05/12/2019

**Sydney Metro Victoria Cross OSD
Stage 2 (SSD-10294) & Stage 1 Modification (SSD-8874-Mod-1)**

ATTACHMENT A

COMPARISON OF APPROVED AND MODIFIED ENVELOPES

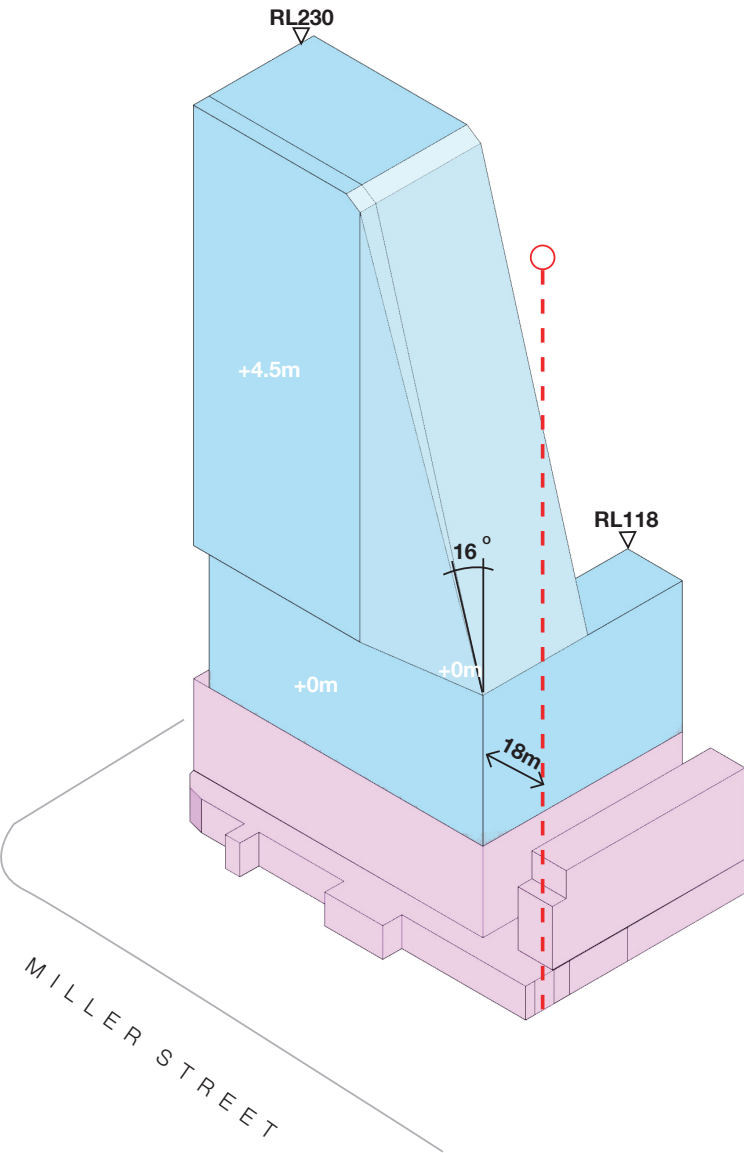
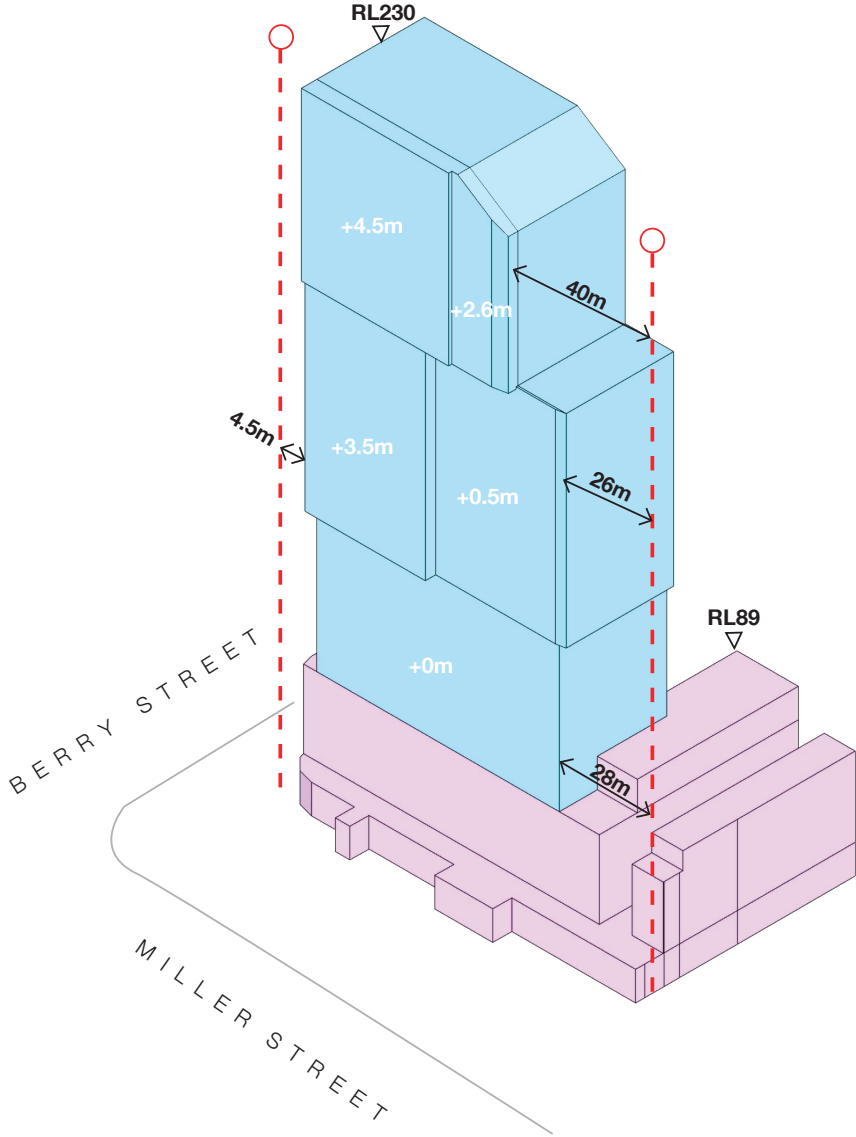
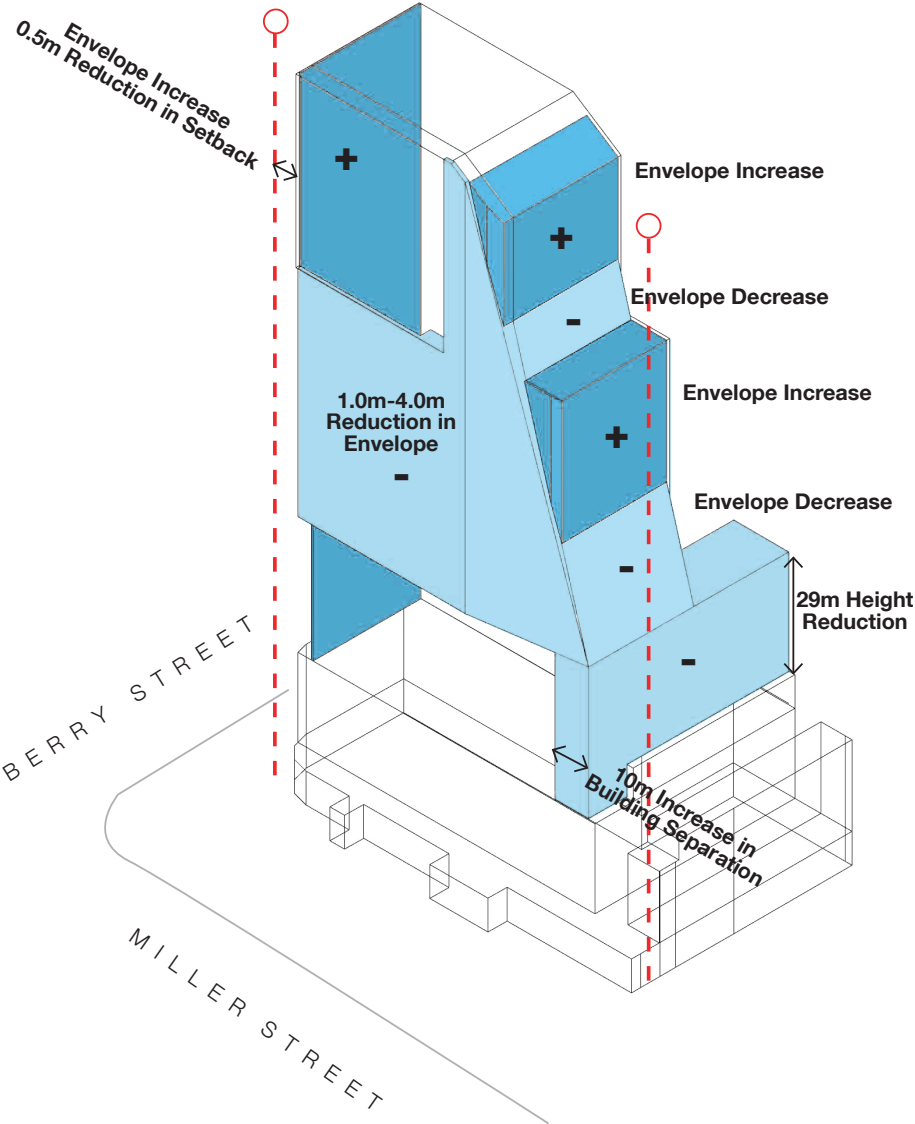
- a) the design of the tower within the articulation zone and how the specific design criteria in the approved Design Guidelines have been addressed
- b) the proposed modifications to the building envelope and distribution of massing in relation to the view loss and amenity concerns raised in public submissions
- c) Condition A15 which requires the building not to exceed the approved building envelope.
